Your Ref: ACP-324568-26

Our Ref: SID-DG-2026-041

Proposed Strategic Infrastructure Development (SID): Barnesmore Gap Greenway Project, County Donegal.
--

Outlined below are heritage-related observations/recommendations of the Department under the stated headings.

A1 SCALE 1:75
A3 SCALE 1:150

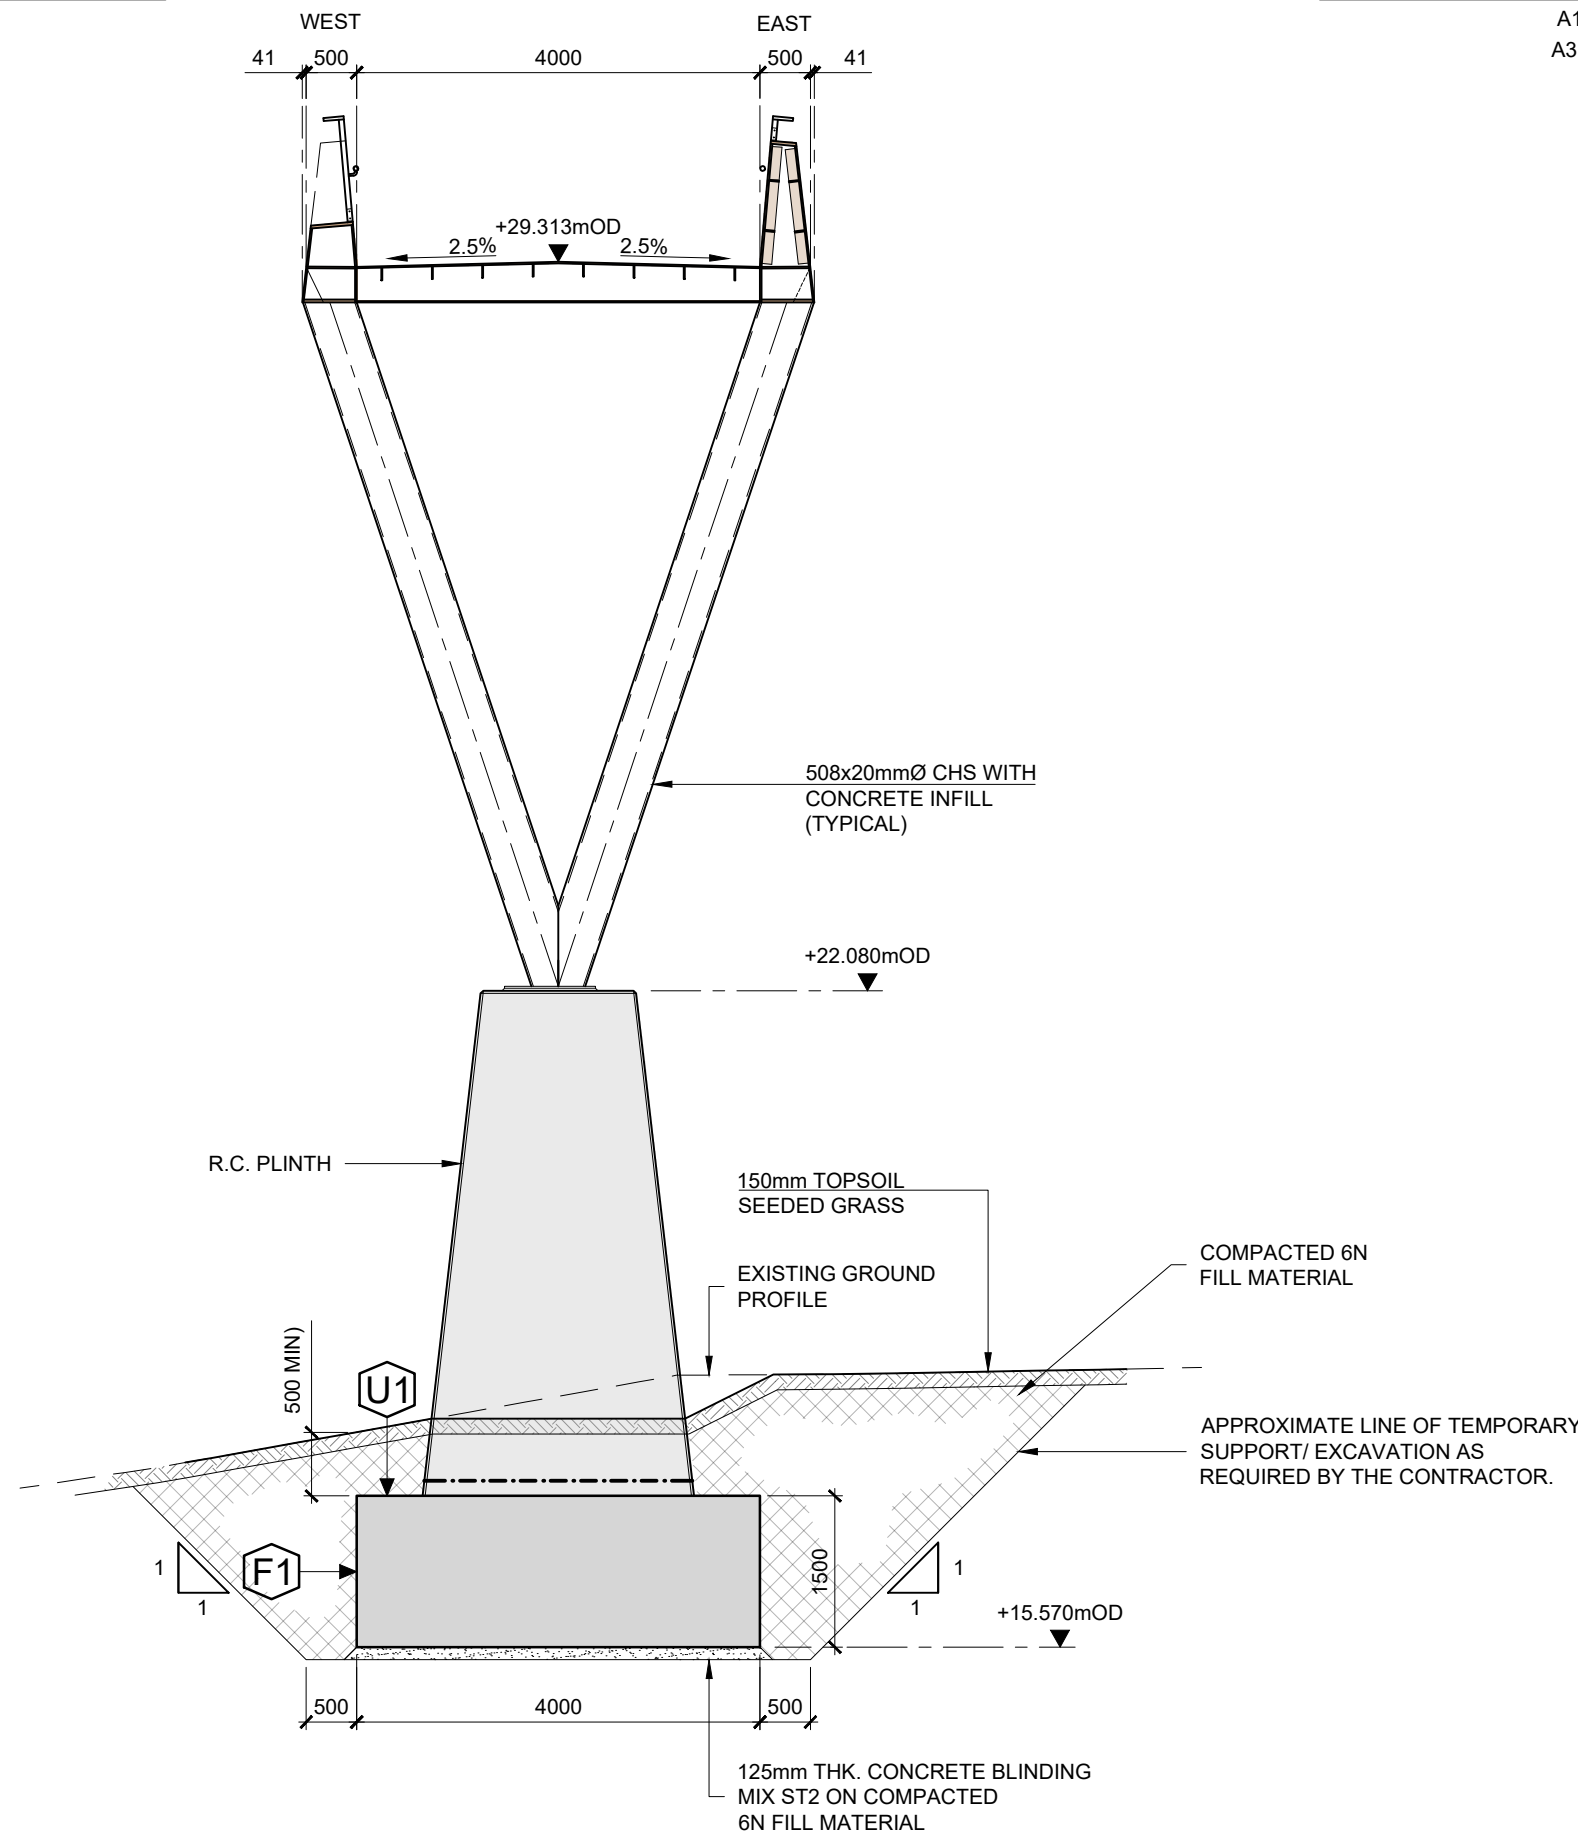
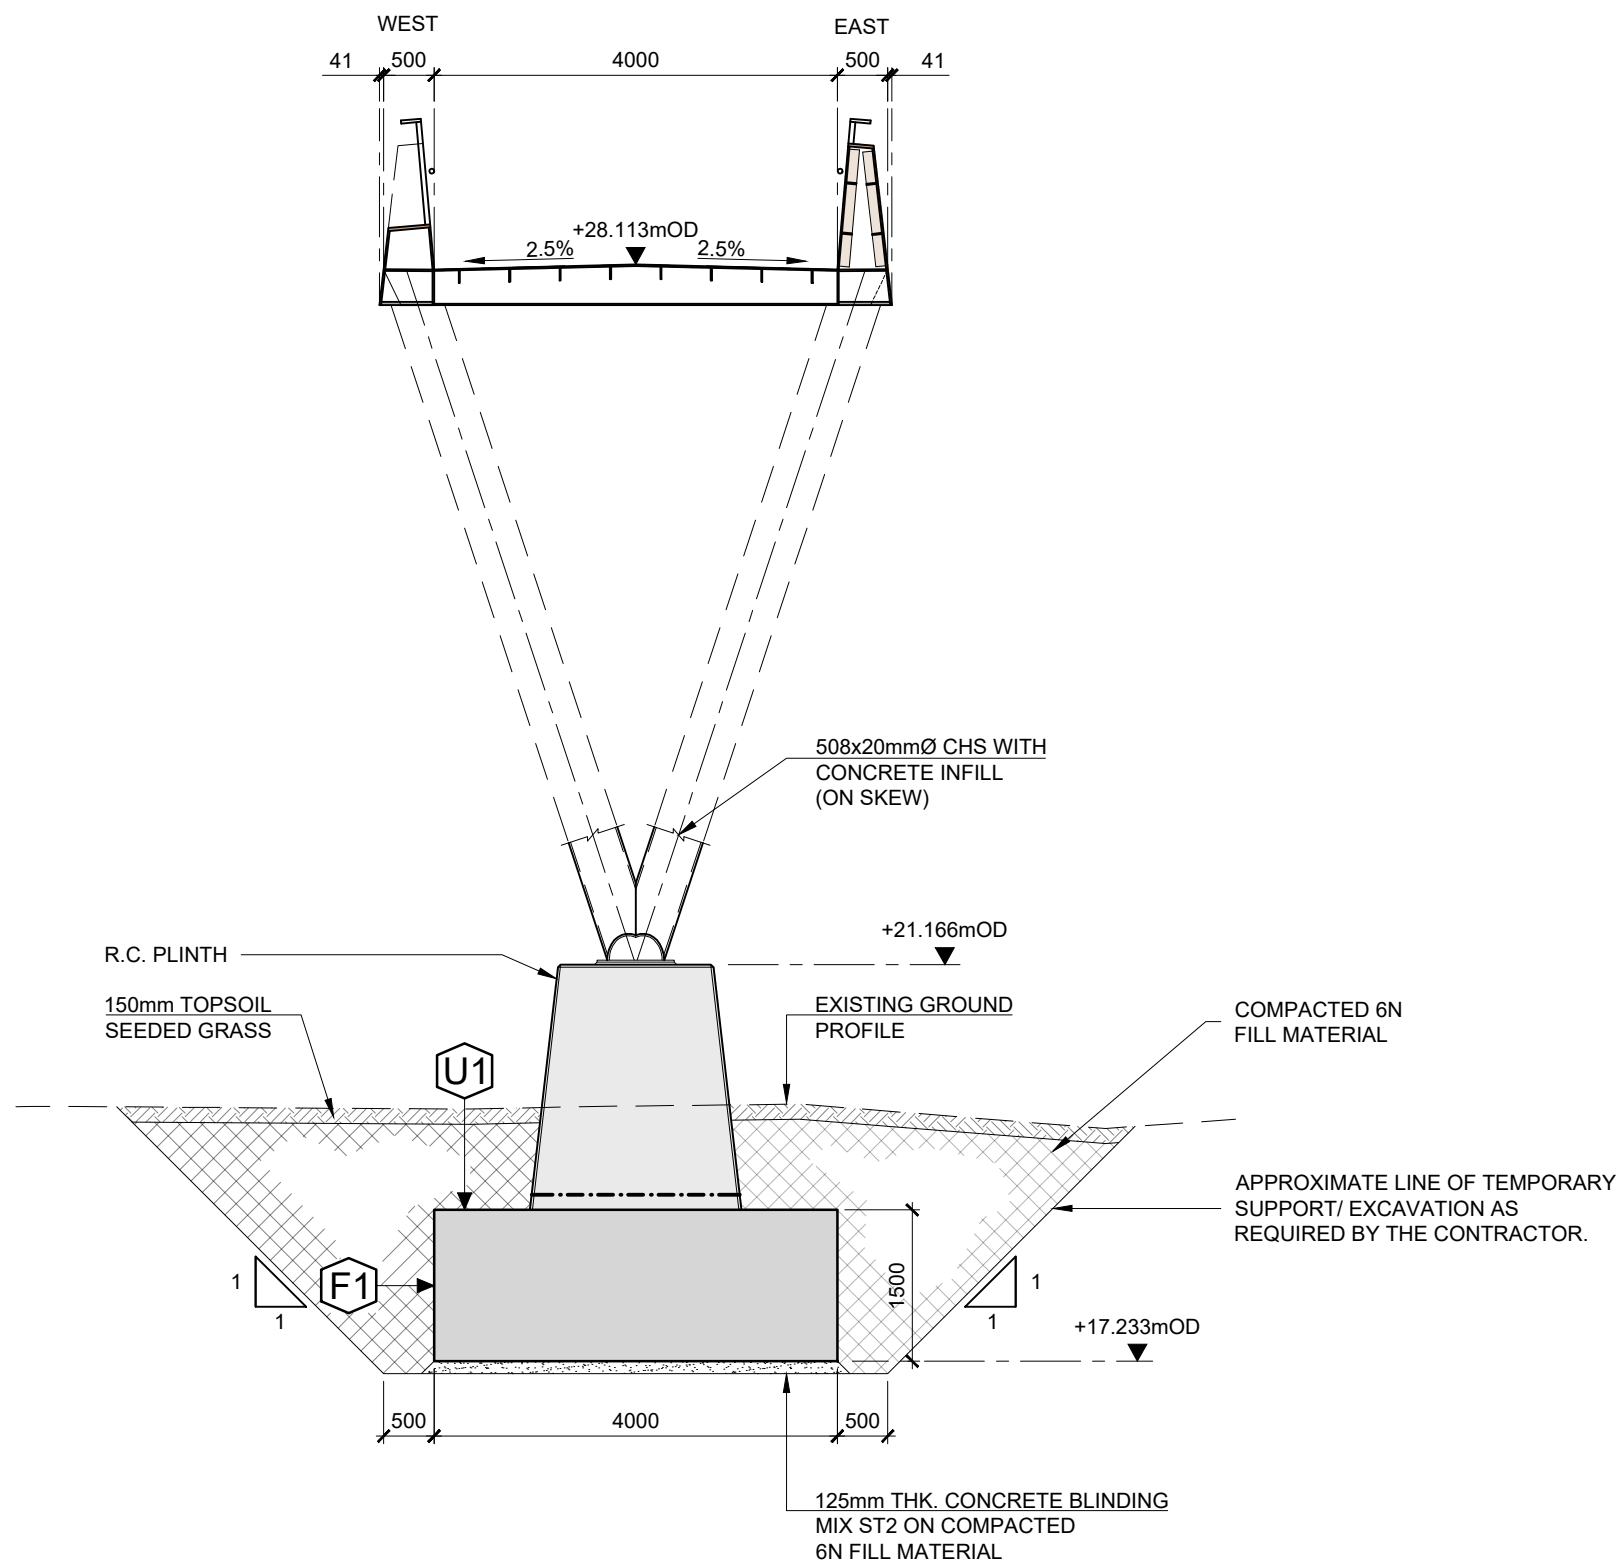
A detailed site-specific construction method statement for the proposed River Eske crossing is required, including bridge foundations, working areas, temporary access, lifting/scaffolding, concrete operations, runoff management, pollution-response procedures, environmental supervision and construction-phase water-quality monitoring. Furthermore, the commitment to no instream works, no riverbank excavation and no direct outfalls to the River Eske should be explicitly secured.

Figure 3-3 - Comparison of the Sum of the Baseline Lengths with the Total Post Construction Lengths for Linear Habitats

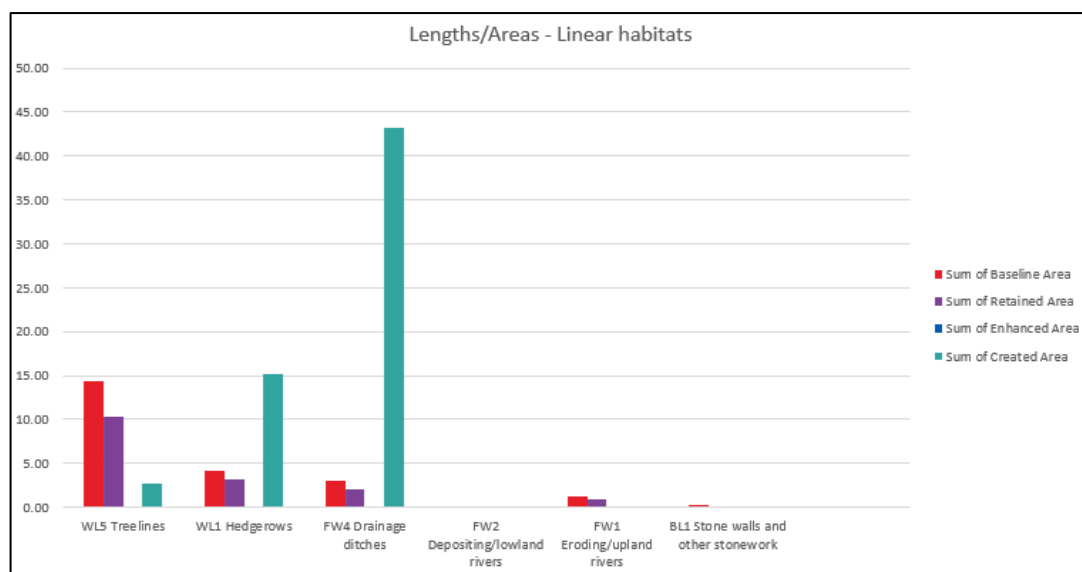
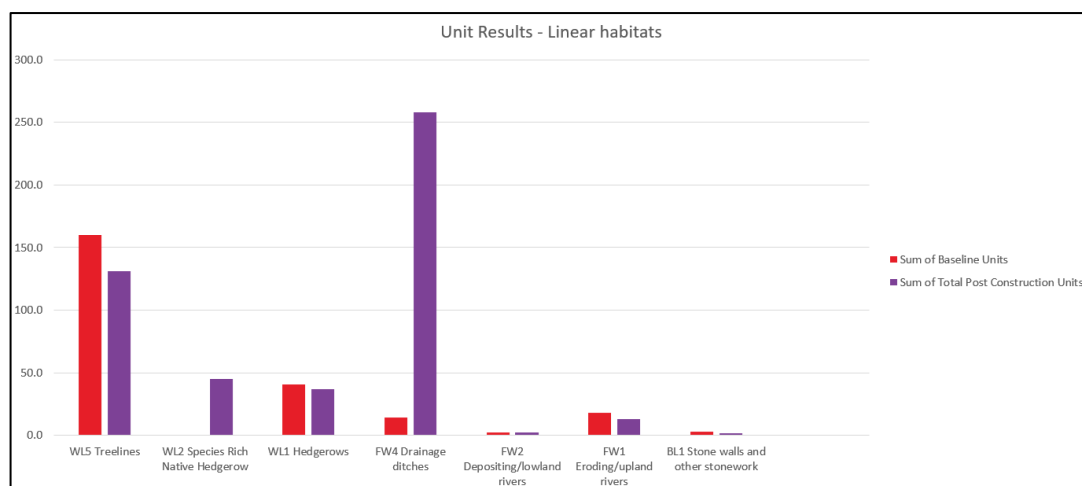
The Department also recommends clarification of the biodiversity accounting presented for the project, particularly the treatment of losses of wet heath and ancient/long-established woodland relative to proposed gains in linear habitats, together with appropriate long-term habitat management, monitoring and protected-species measures.

A revised or clarified biodiversity-accounting schedule is required showing area and linear biodiversity units separately, together with clearly defined long-term compensation and/or restoration measures for loss of wet heath and ancient or long-established woodland.
